Subject: RE: Middleton House - M/39/17/HH - M/94/18/DOC - OPTION 3 ATTENUATION TANK

Middleton House - M/39/17/HH - M/94/18/DOC

Please accept this email as our formal submission of partial discharge of planning condition No 6 -- Option 3

PROJECT	MIDDLETON HOUSE YAPTON ROAD MIDDLETON PO22 6DU
DRAWING	PROPOSED DRAFT SW DRAINAGE LAYOUT OPTION 3 - ATTENUATION TANK - CONNECTED TO CS
SCALE	FC2780/2.3
DATE	1:100
DATE	OCT 18
INITIAL	MH
CHKD	-
REV	-

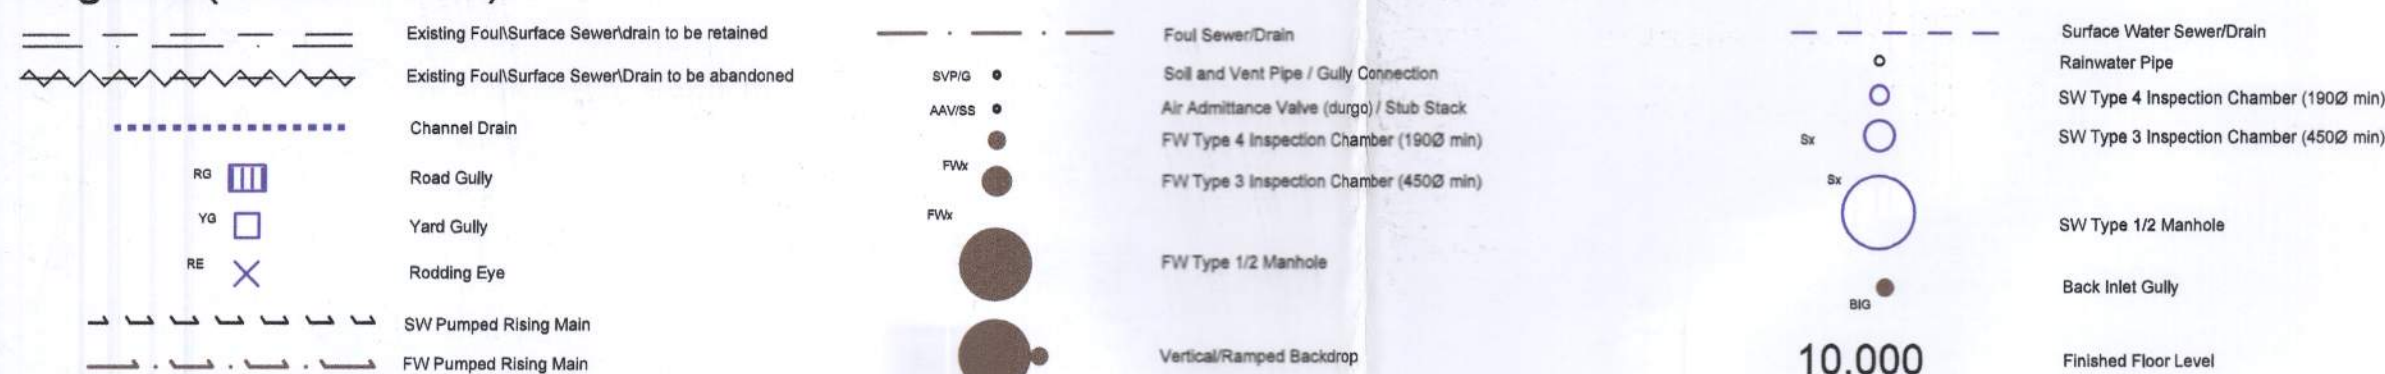
I will be happy to recommend the partial discharge of the condition when the formal application comes in to allow works to start on site. This is based on the fact that there is sufficient room on site for the three options provided.

The condition will not be able to be fully discharged, and can we state that occupation is not permitted until it is. I will require the groundwater monitoring and infiltration testing to be completed not before December and the options to be reviewed based on this. Option 1 or 2 should be pursued first. I expect the design to be revised based on the infiltration test results and will need full construction details to be submitted at this point to fully discharge the condition. Construction of the surface water drainage will then need to be completed in accordance with the approved plans.
